Project Name: **Lot #1 Second Tee Business Park (1039 Riverside Street) – new building**  
Project ID: #2017-034  
Address: Unit #1 (also known as 1077 Riverside Street)  
CBL: 331 A001 001  
Applicant: 1039 Riverside LLC  
Planner: Jean Fraser

On May 5, 2017, the Planning Authority approved with conditions a Level II site plan for the construction of a 7,500 sq ft building with 15 parking spaces (shared with Unit #2), for Lot #1 in the Second Tee Business Park. The decision is based upon the application, documents and plans as submitted by the applicant and prepared by Stantec Consulting Services (C-1 to C-3 and C6 to C10 dated 2.16.2017; C-4 dated 4.24.2017; and C5 dated 4.19.2017) and Elevations Sheet 1 dated 2.17.2017. by Michael Charek Architects. The proposal was reviewed for conformance with the standards of Portland's site plan ordinance.

Drawing file: Level II April 2017 Unit 1 / superceded Final Site Layout Plan Unit 1 4.24.2017.pdf

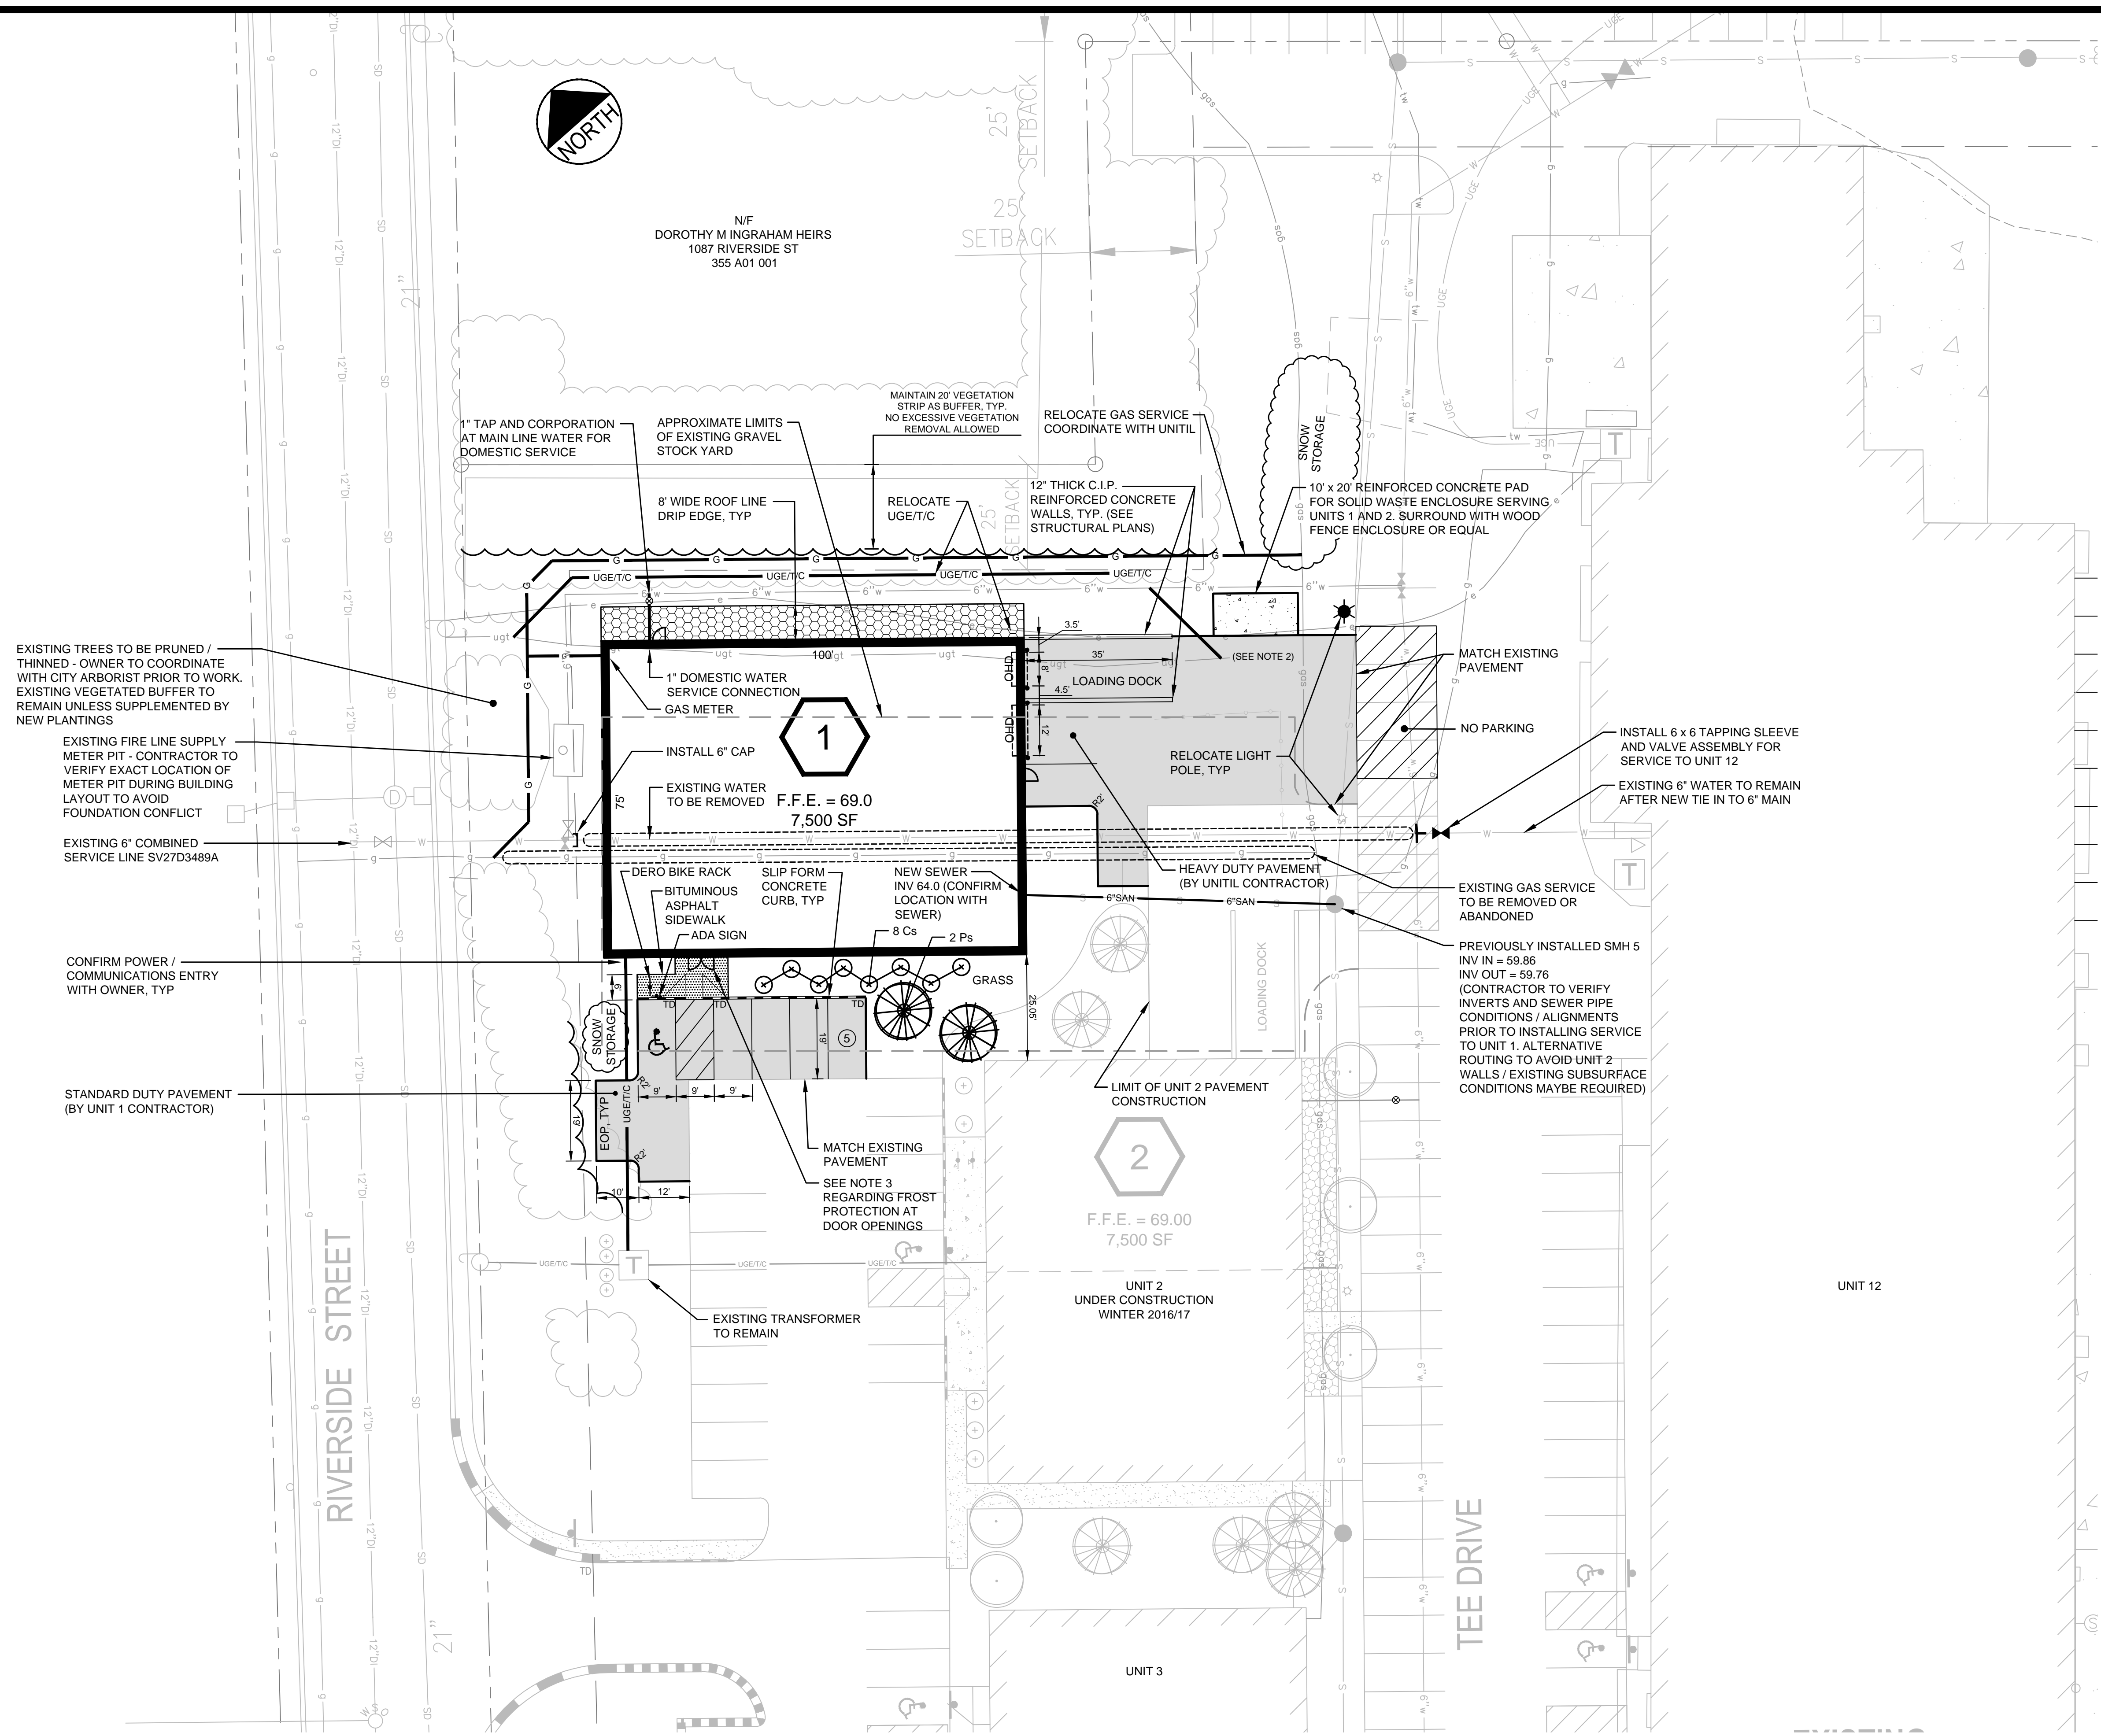
- i. That that applicant shall revise the Site C-4 Site Layout Plan dated 4.24.2017 to include a paved pedestrian facility connection from the building to the sidewalk on Riverside Street, for review and approval by the Planning Authority prior to the issuance of a building permit; and
